Hartfield Place, Swords Road, Whitehall, Dublin 9 Road Scheme

Quality Audit – Additional Information/Responses
from Designer

Eastwise Construction Swords Ltd

29 March 2022

Drawing file: Engineering / HARTPL-JOR-SM-ZZ-DR-C-0002 (Site Services Surface Water Drainage Layout).pdf

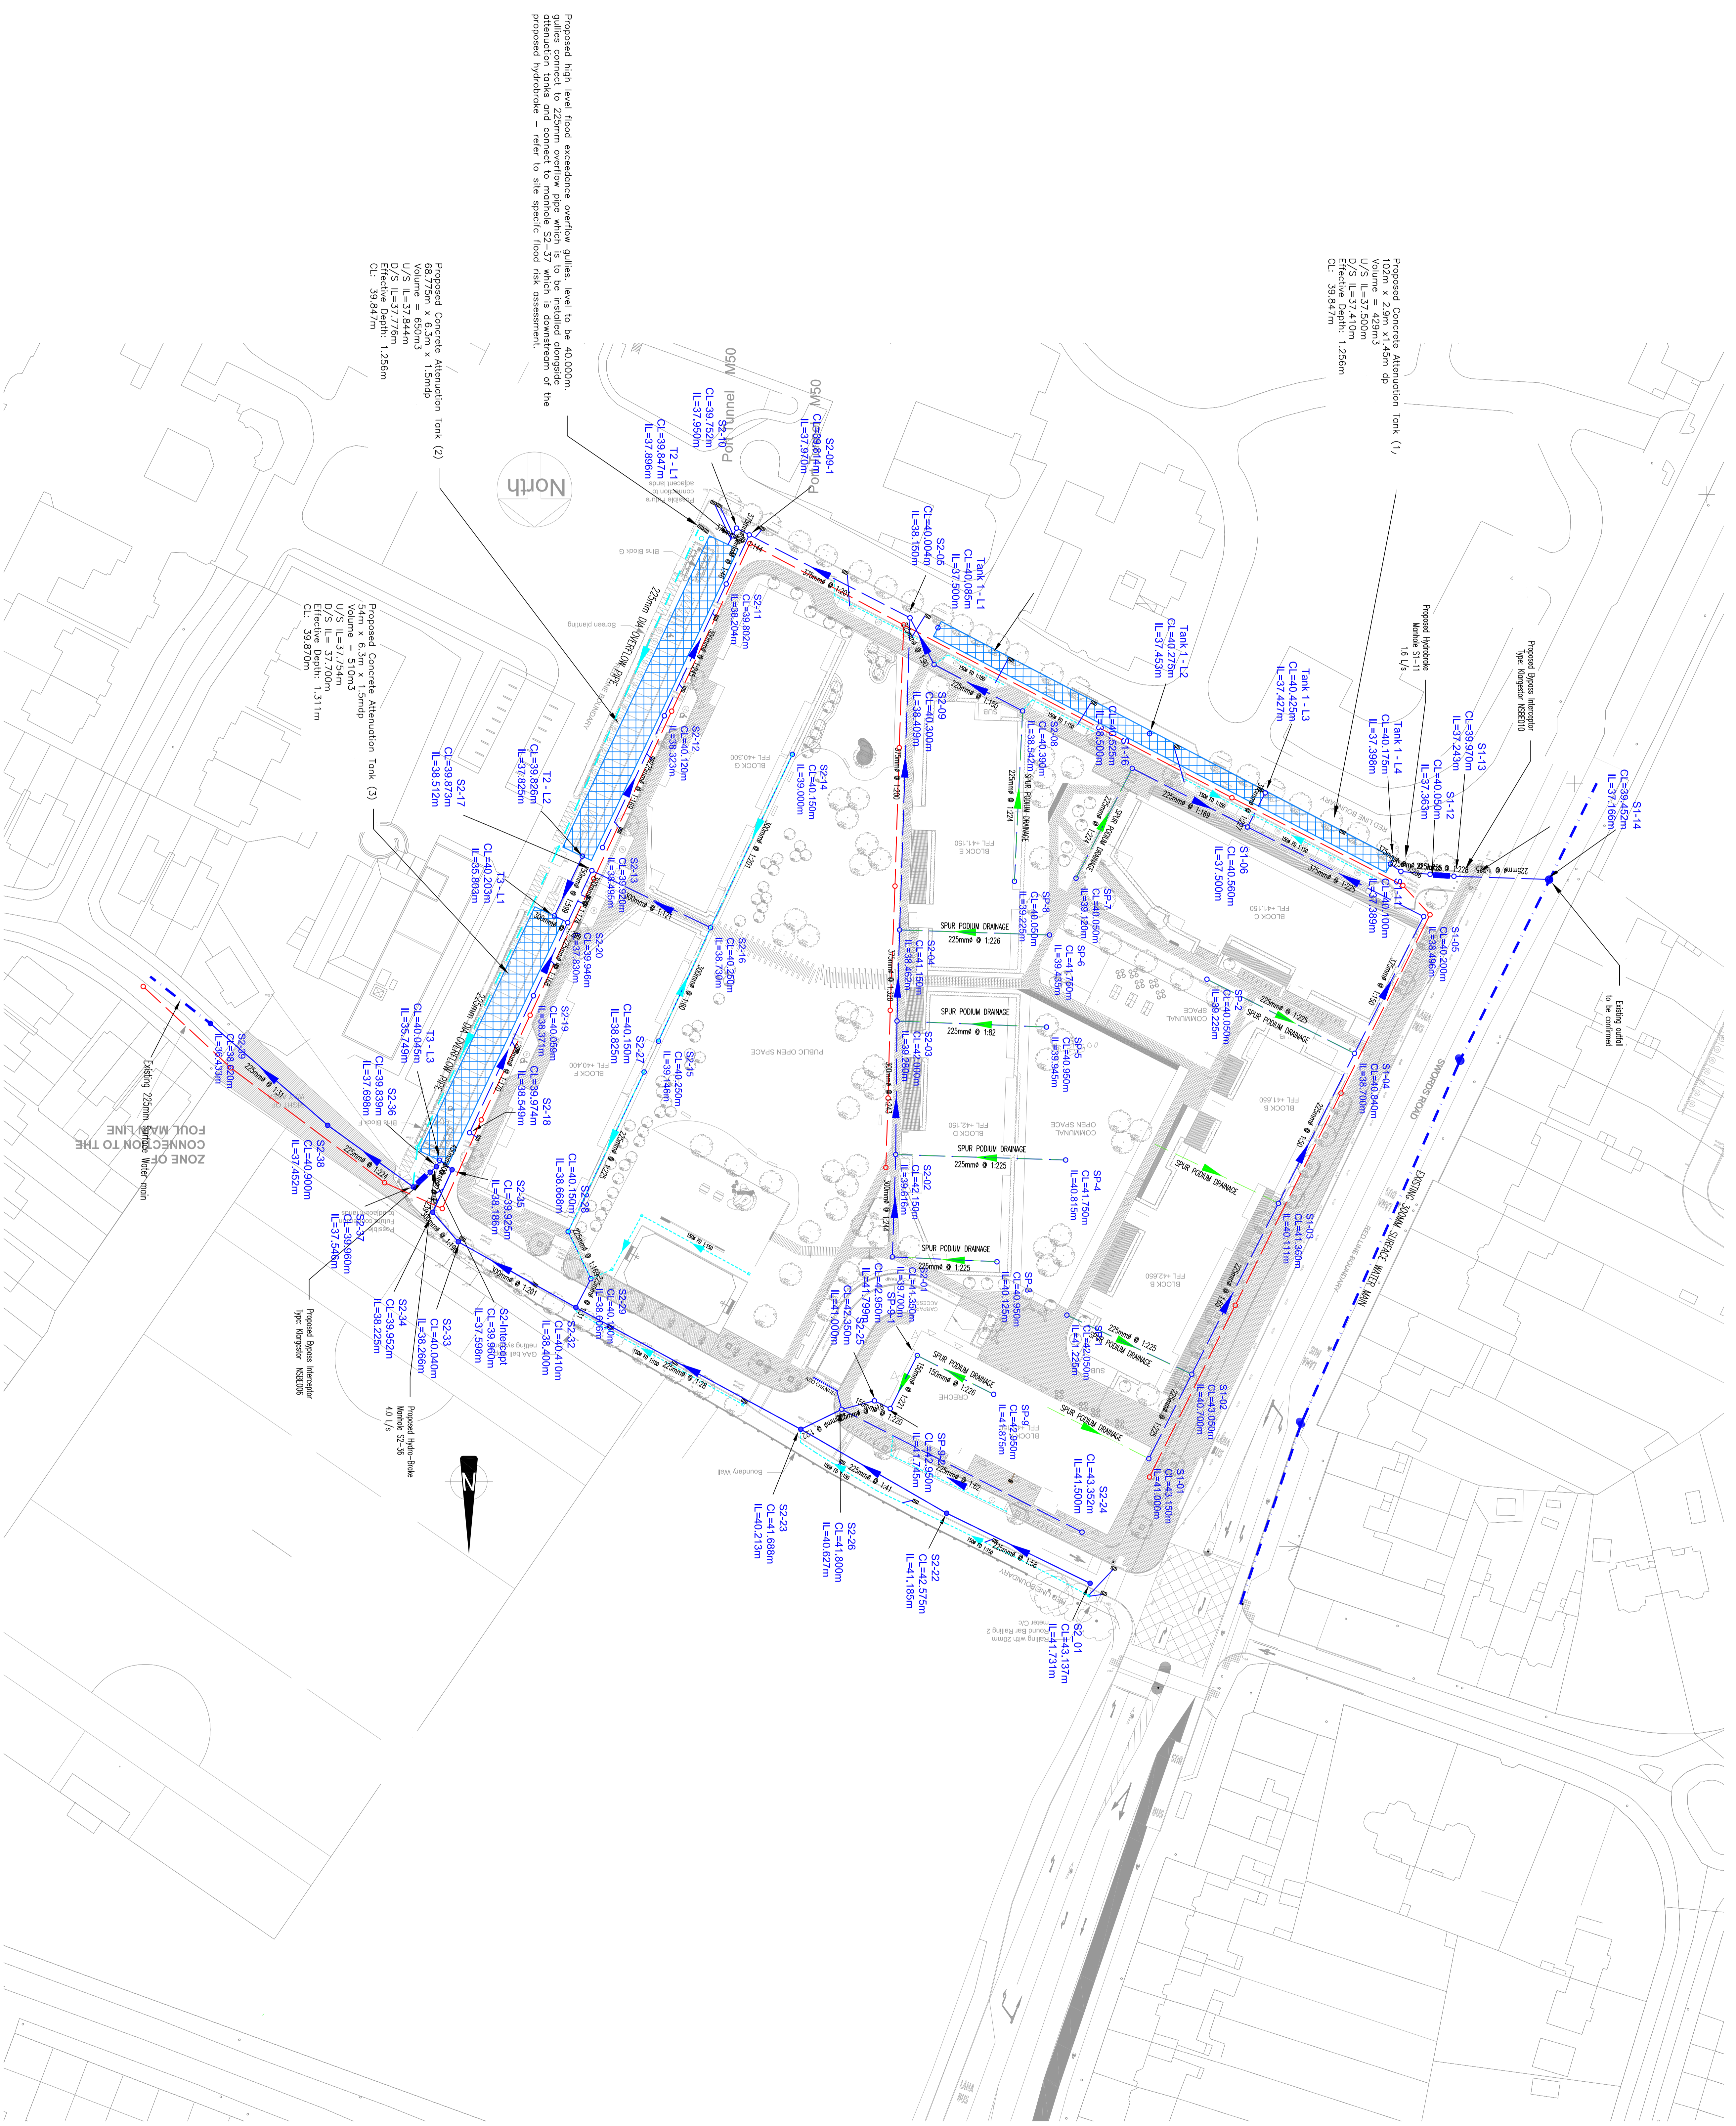
The audit team note from the drawings provided that there is no provision for drainage channels/ gullies positions for the proposed stormwater network throughout the proposed development. Inadequate gully positioning may lead to issues of ponding in areas of the development which poses a risk of slips, trips or falls to vulnerable road users.

The drainage design has been developed and details and locations of all drainage gullies etc are provided for across the site and positioned strategically to avoid the risk of ponding across the site. This information can be provided at detailed design stage.
